# SYDNEY FOOTBALL STADIUM

RESPONSE TO SUBMISSIONS

LANDSCAPE AND PUBLIC DOMAIN

DATE: AUGUST 26, 2019

1 STAIR TYPE 1.1- PRECAST CONCRETE| MAIN ENTRANCE | DETAIL PLAN 1:50 PLAN ST1.1

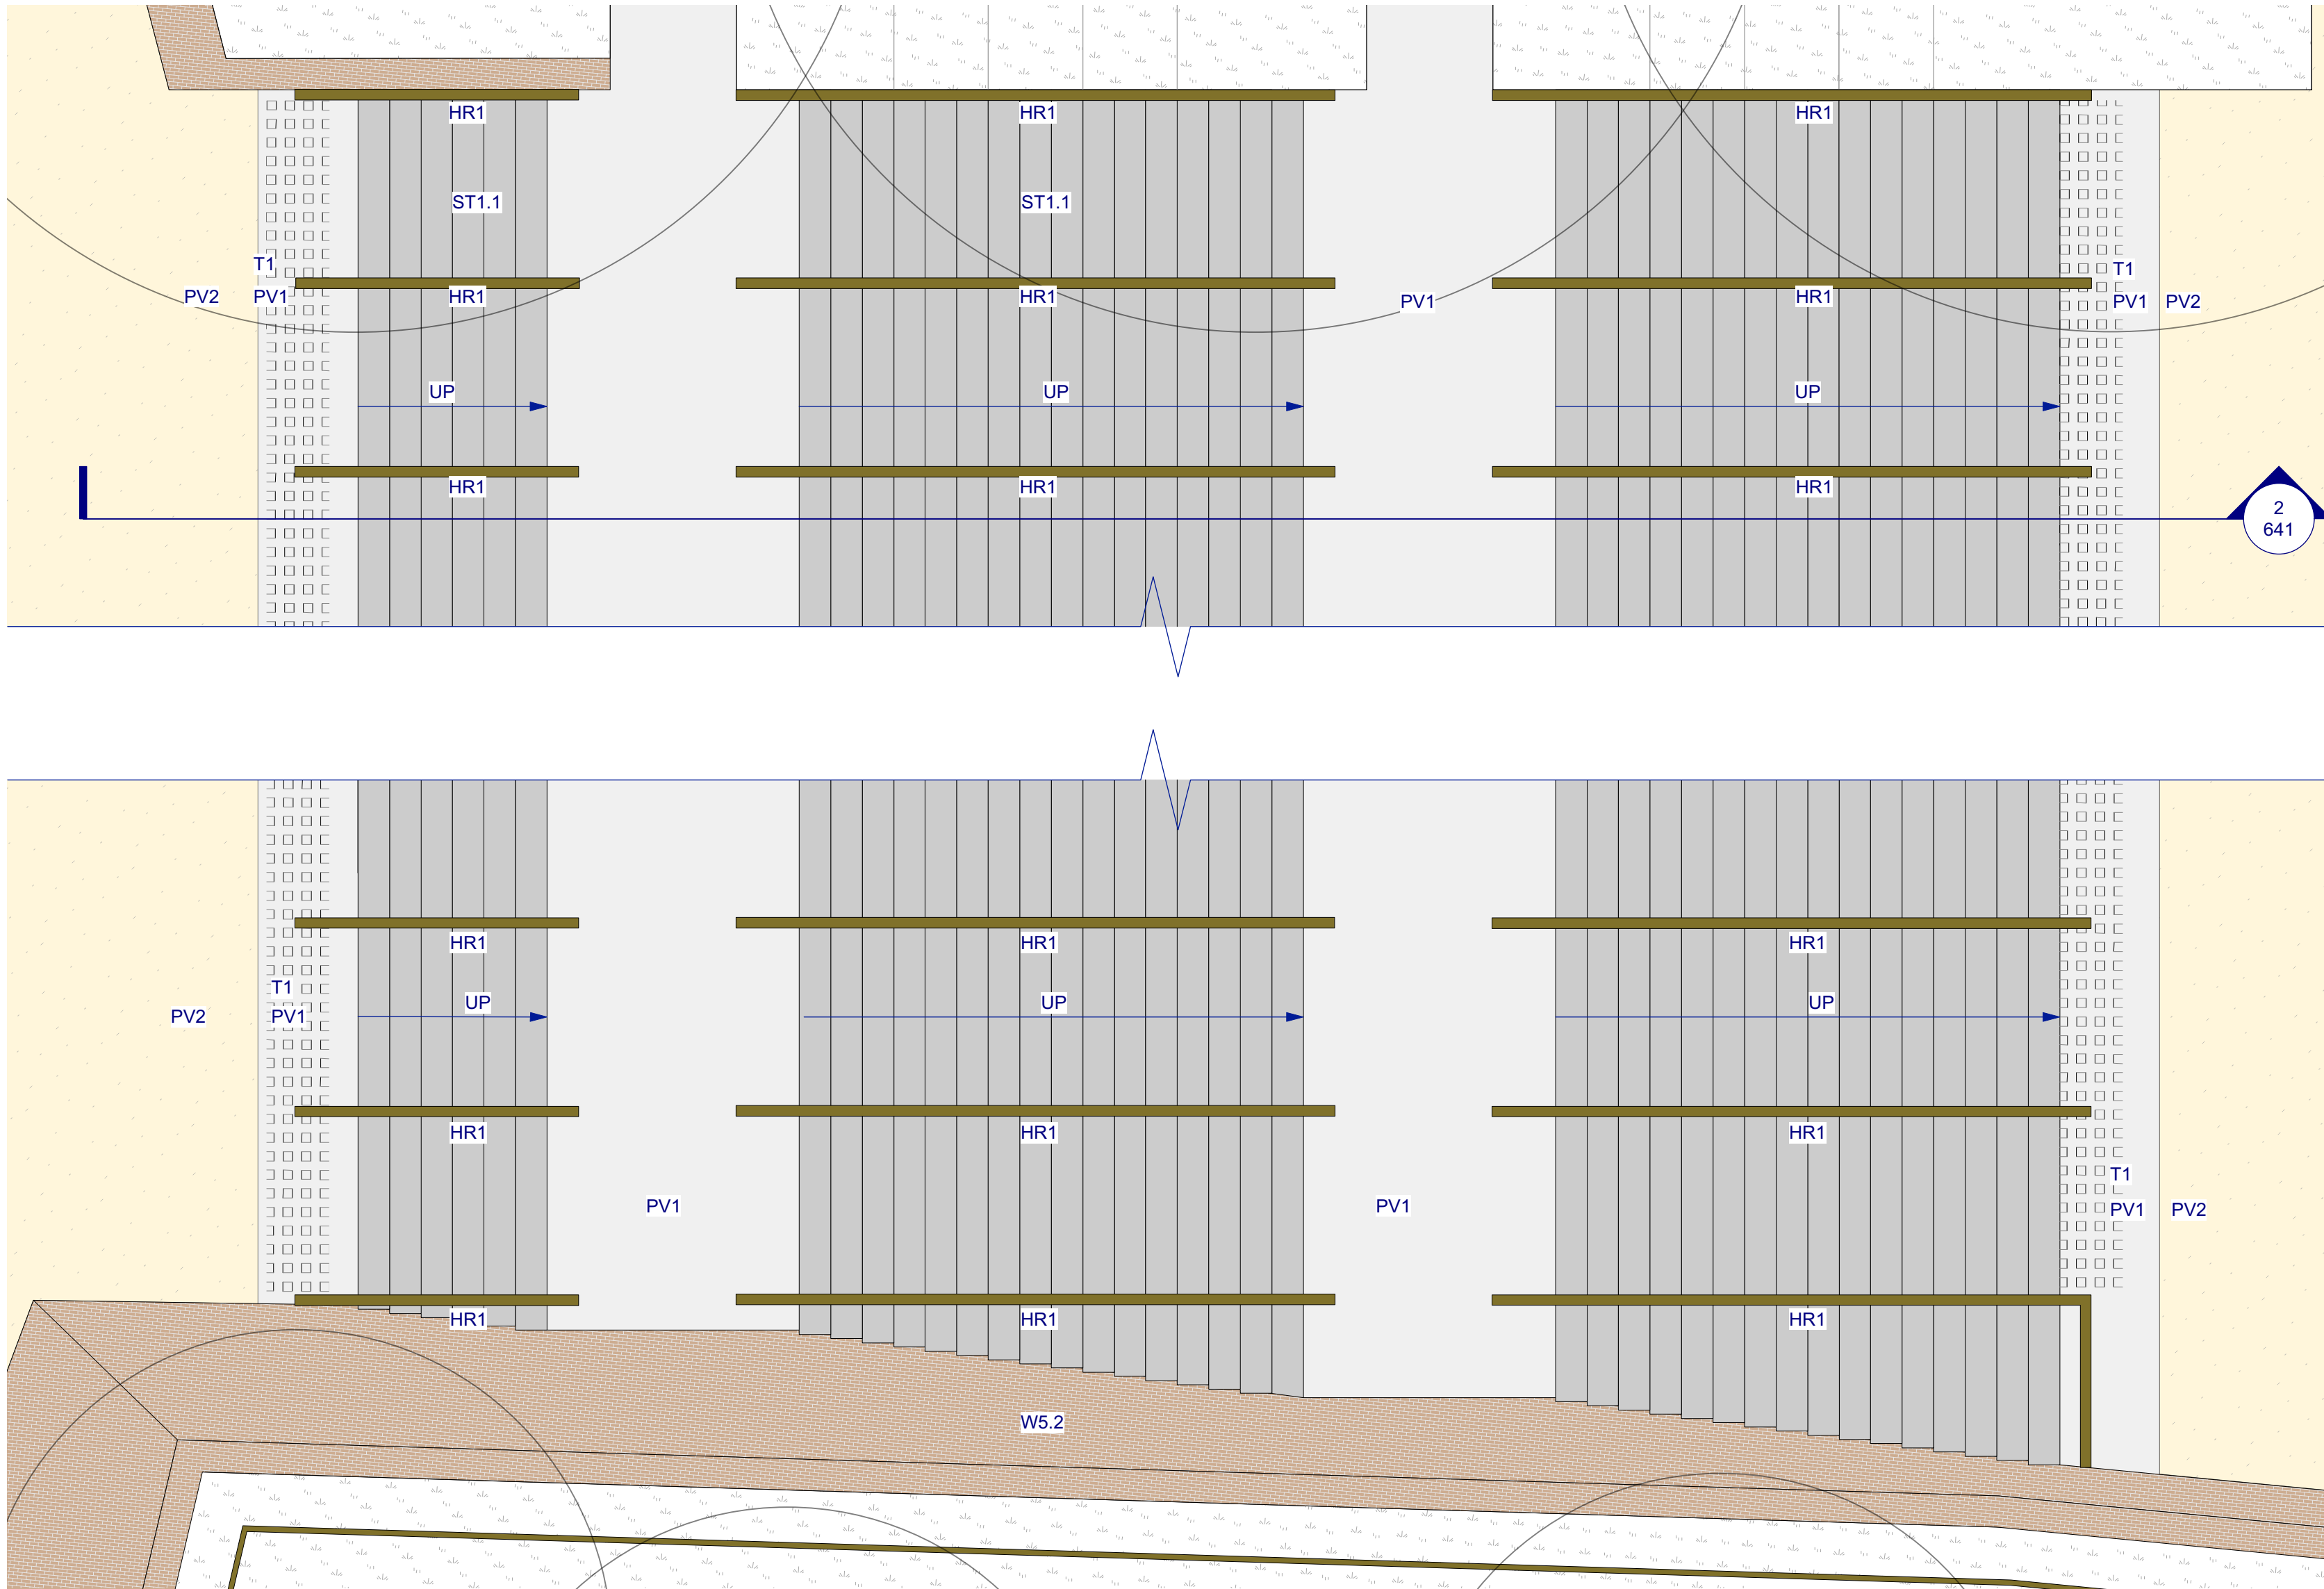
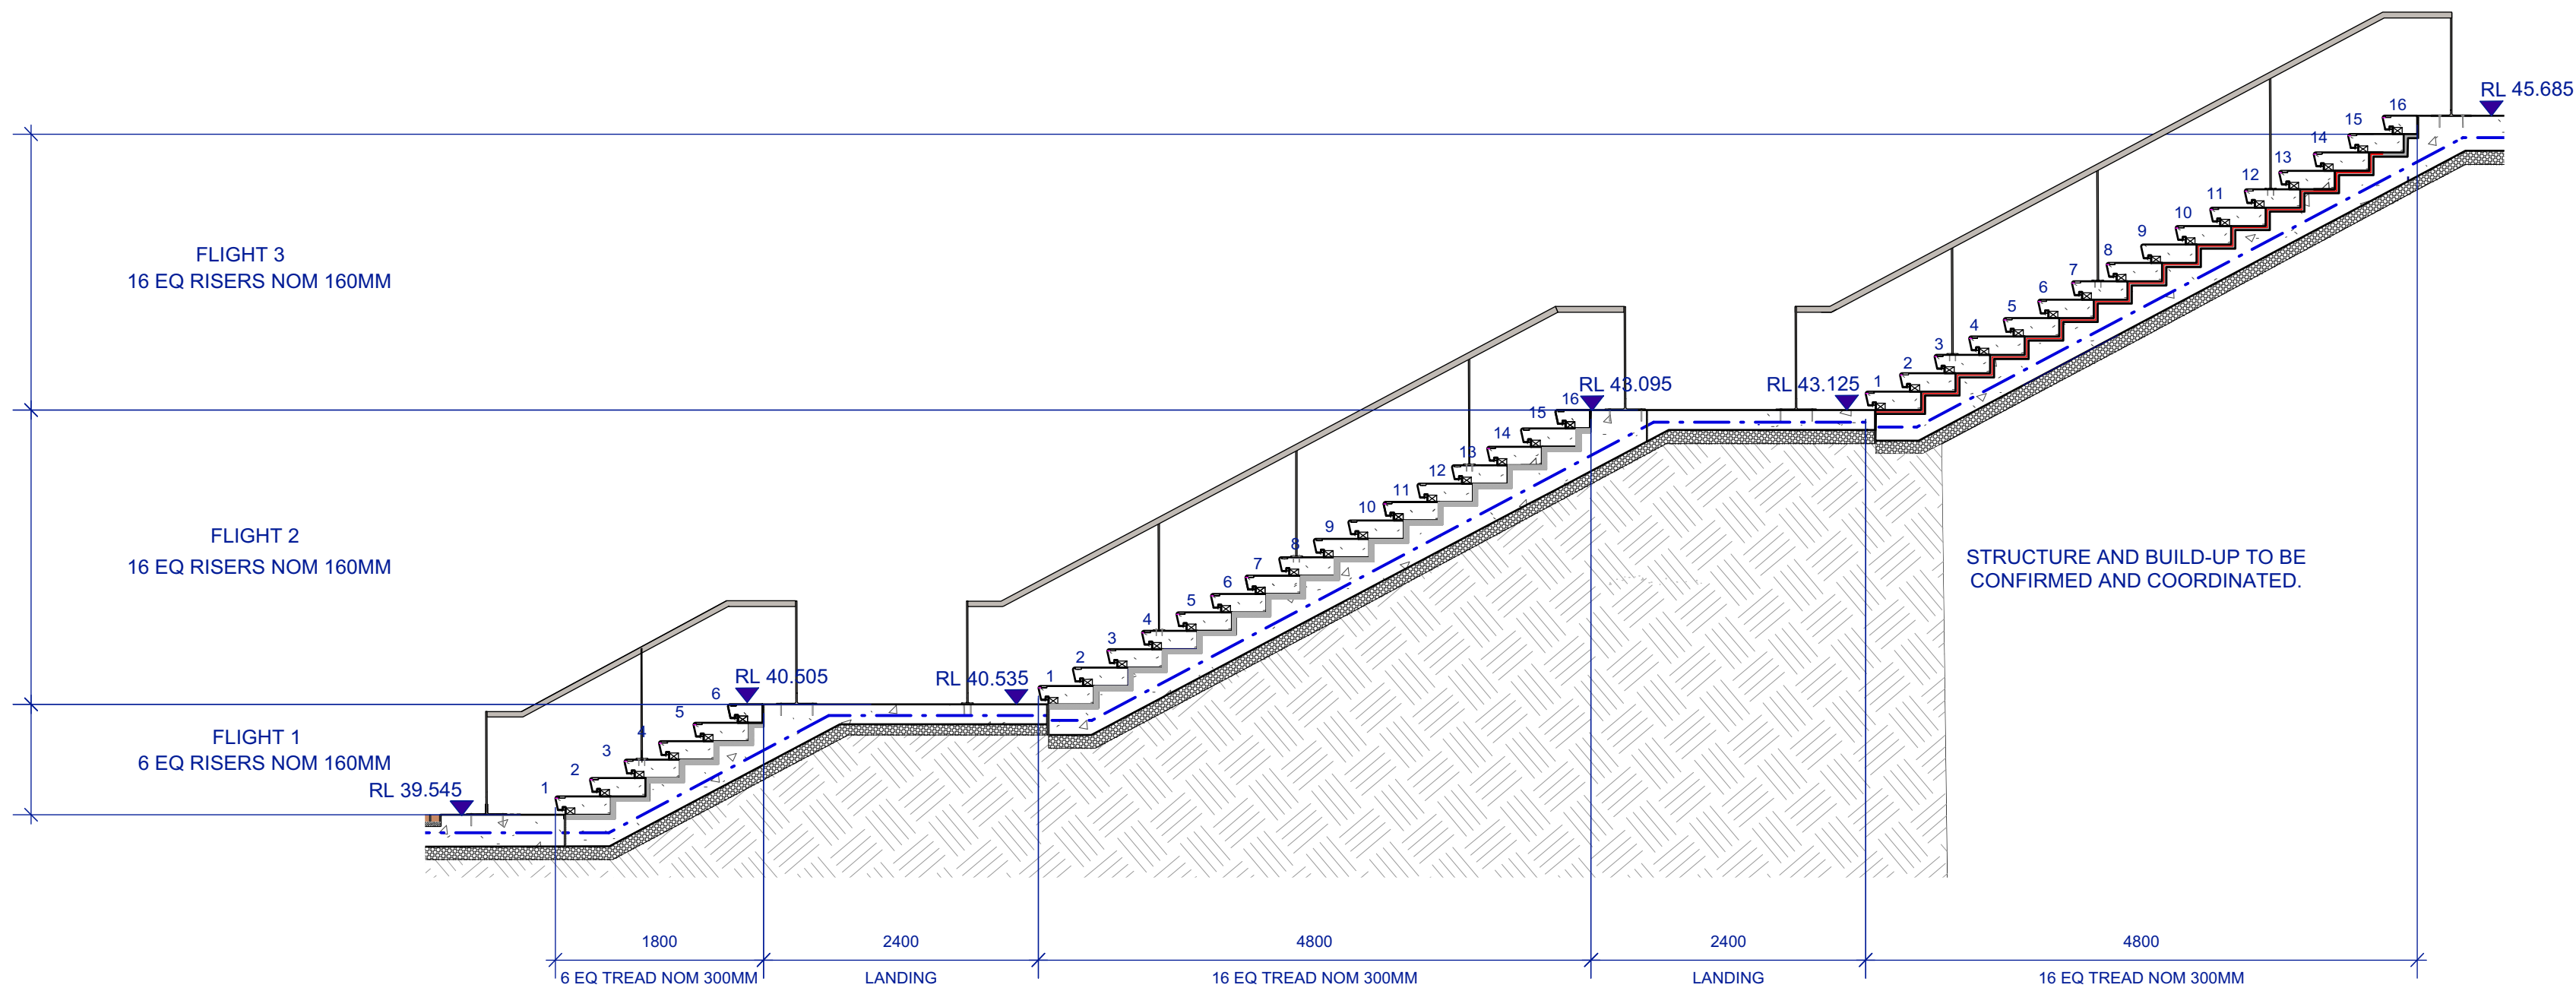
3.0 Insufficient Information 3.6 Landscape	There are discrepancies with the number and extent of flights of stairs at the Driver Avenue entrance to determine if the flight dimensions are acceptable.	<p>The Architectural and Landscape plans have been reconciled to address this comment. The revised drawings are provided in the Design Report that support the Response to Submissions.</p> <p>The Moore Park Stairs can be divided into the Western and Eastern stairs. The Western stairs are compliant to AU and BCA standards.</p> <p>The number of risers associated with the Eastern Moore Park Stairs do not conform with the BCA (38 risers in lieu of 36), this non compliance will be addressed by means of a performance solution meeting the relevant performance requirements through an expert human movement consultant.</p>
